Your Ref: OWPC23173
Our Ref: M/42/19/PL 10-05-2019
Please ask for:
Andrew Wood

Demolition of existing dwelling & erection of pair of semi-detached chalet dwellings with on-site parking facilities & new vehicular access.

117 Elmer Road Elmer

Thank you for your internet representation made on 24th May 2019 which has been recorded as '**an objection**' with the comments as follows:

sheet 3 of 4

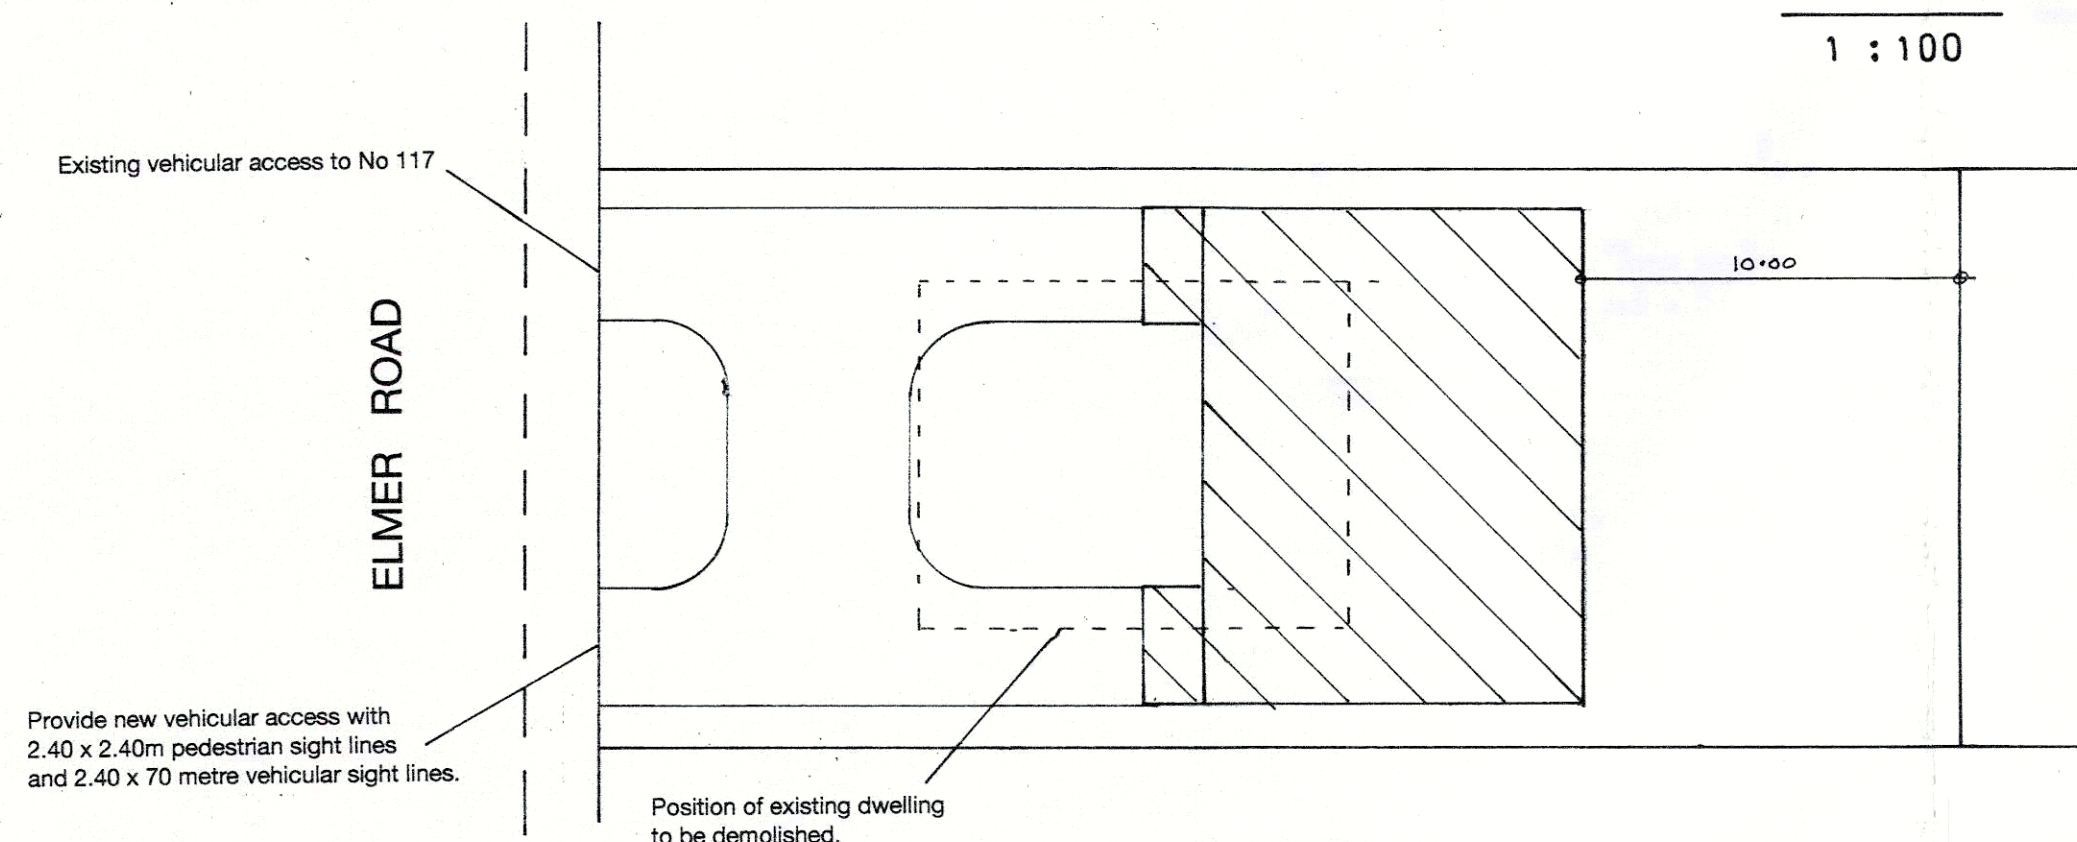
- 8. 115 and 115a are unattractive houses to replicate, why not improve on that design and not copy it?*
 - 9. 127 can fit three cars maximum and two very comfortably and they are positioned near the front of their plot (photos attached showing 127 and also 115/115a, which to my mind looks more like a car park), showing that 117 can have their plans and fit enough cars by keeping to the current footprint.*

sheet 1 of 4

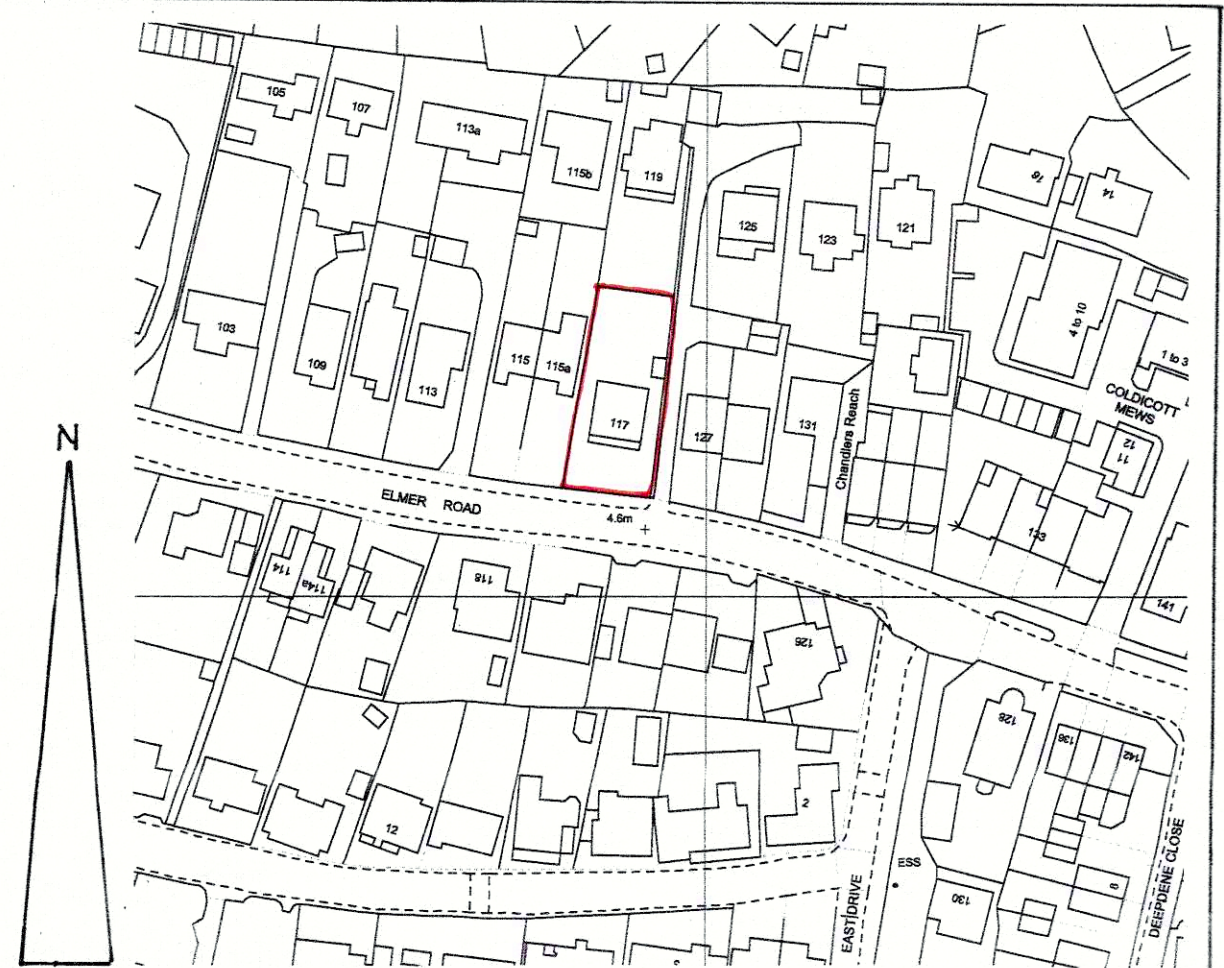
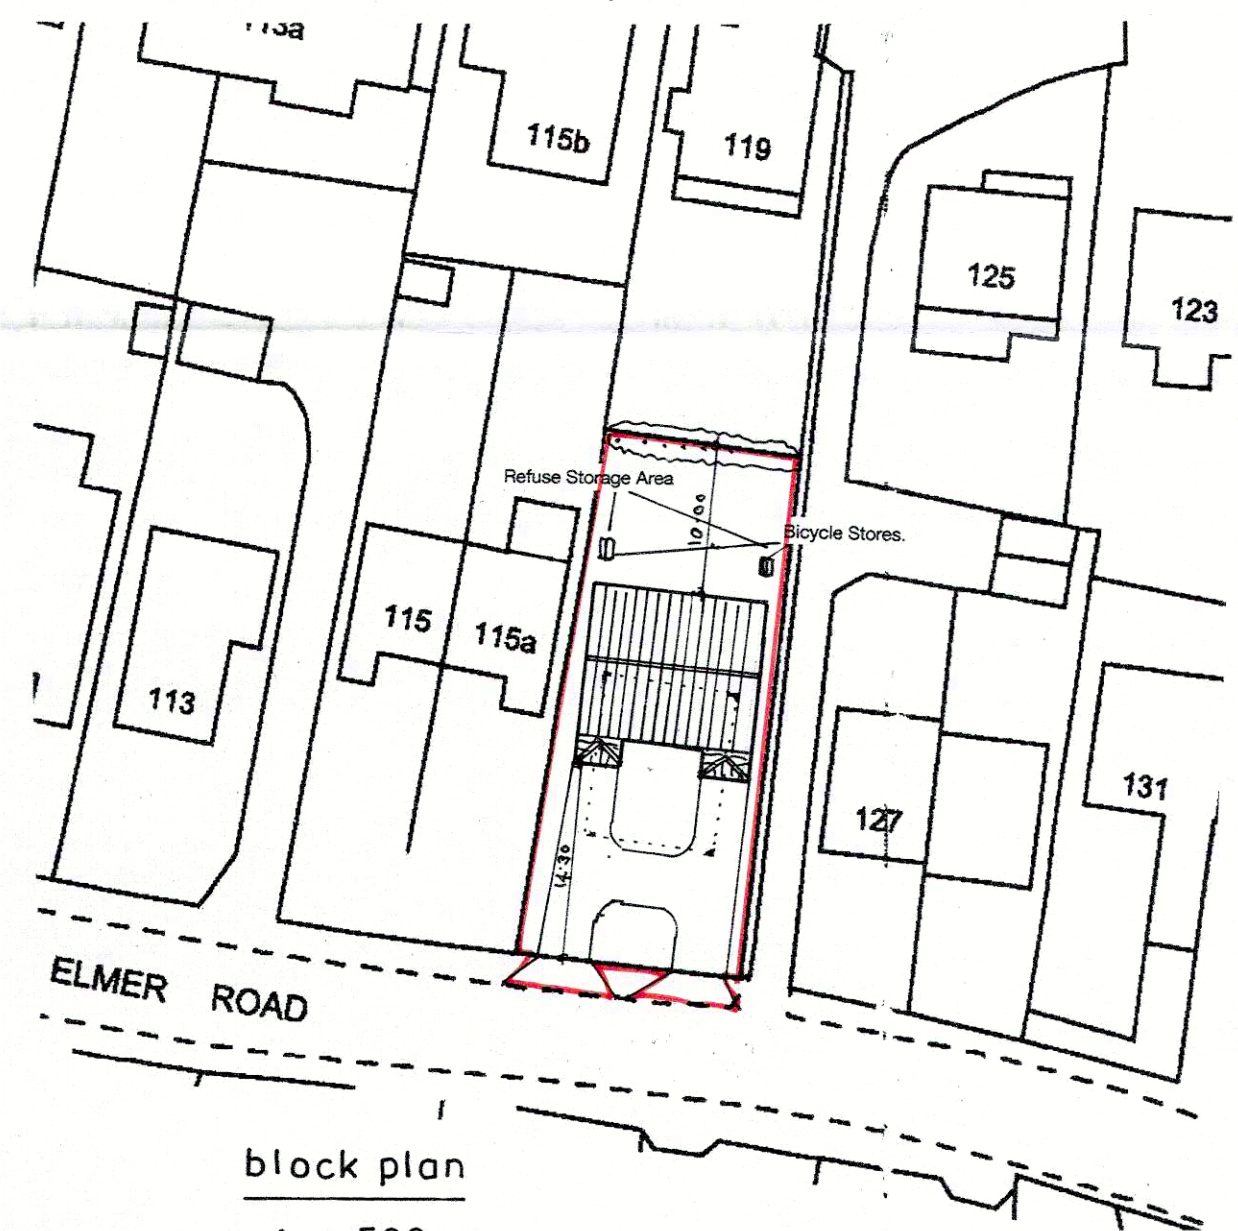
- 3. I cannot believe that the existing footprint is being so wildly changed?? This proposal will see a house that comes so much closer to me, therefore blocking more light than it would have and losing so much more privacy?*

I would also very much like to see the proposed house to be positioned in the exact line with the existing footprint, changing it by a few metres is just not enough. Positioning it where it is proposed totally affects me when it is totally unnecessary as the plans can be made with it staying in line with where it is now. Just because one house next to it is set back doesn't mean this one has to. The bungalow 127 is not set back there and their garden will be completely blocked from its sunlight by the proposed plans.

sheet 2 of 4

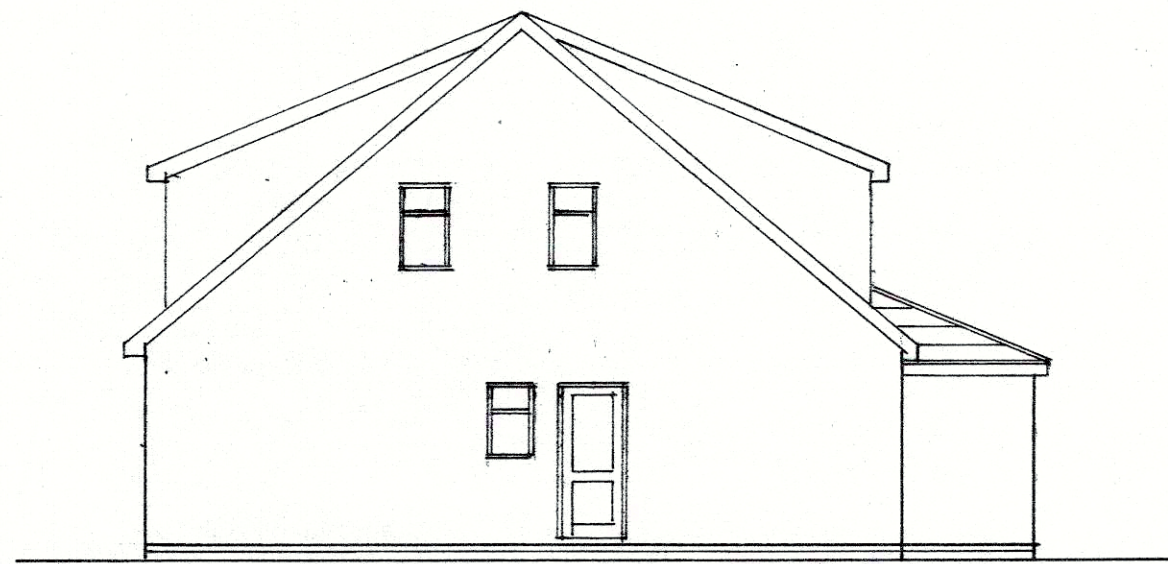
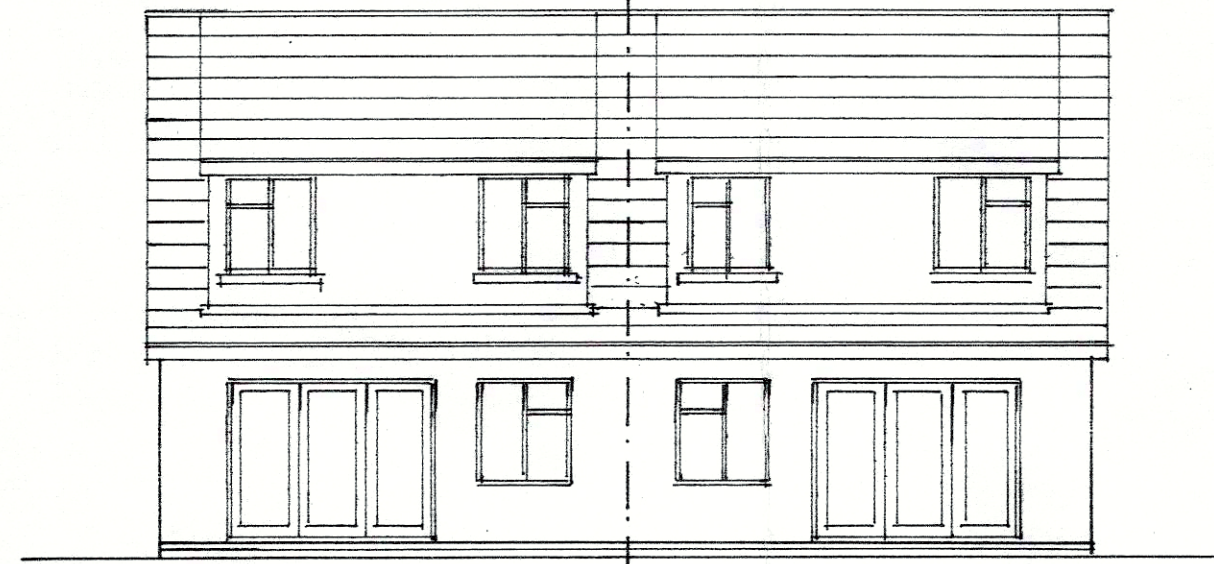
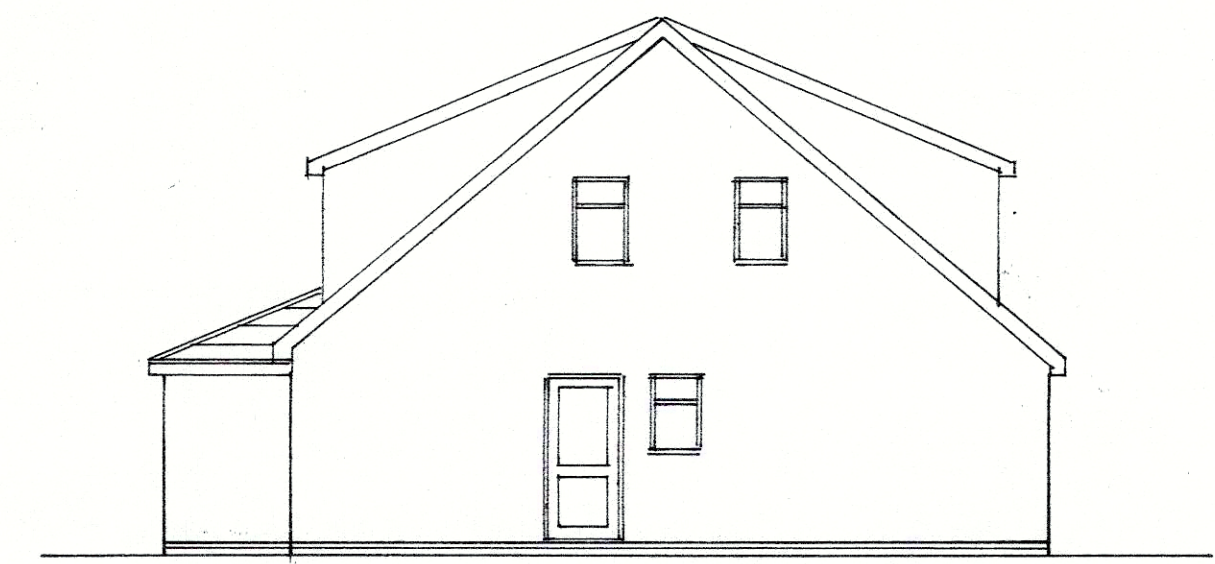
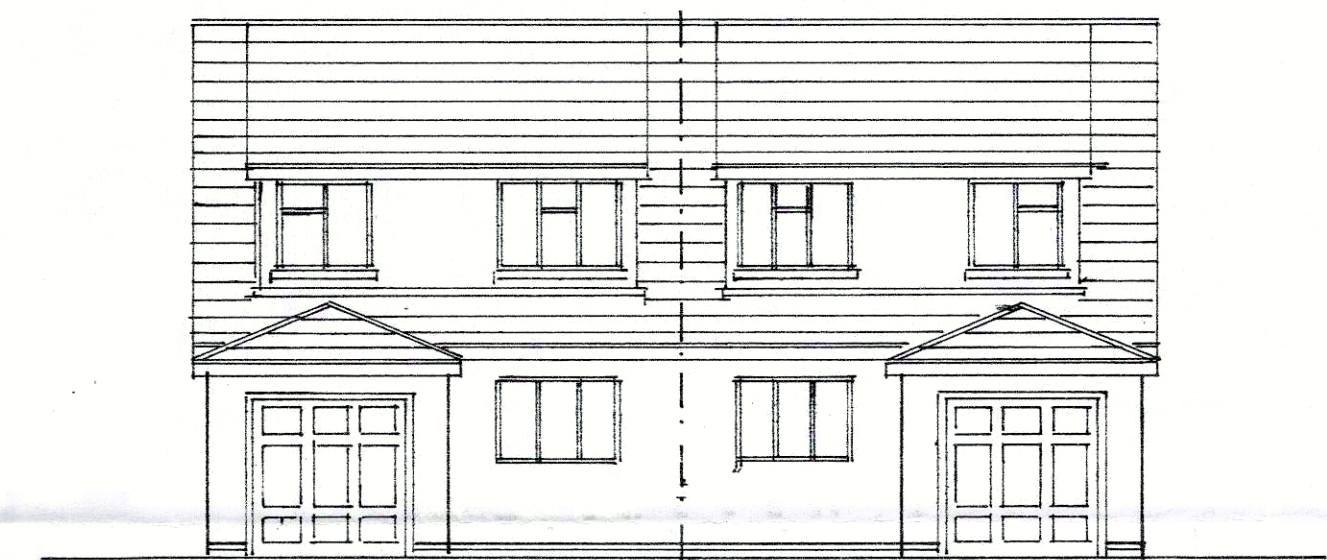
- 4. There is one window looking out from the north elevation at the moment and on this proposal there are 4!. From my upstairs bedroom I will be able to directly to the upstairs windows of the proposed house. Also my lounge will also look directly at the proposed windows and they of course will be able to look into my house.*

I would request that all four upstairs windows are obscured to maintain my privacy. My house has had uninterrupted views and light for 98 years! It's bad enough 115/115a were built but please don't let another one permitted.
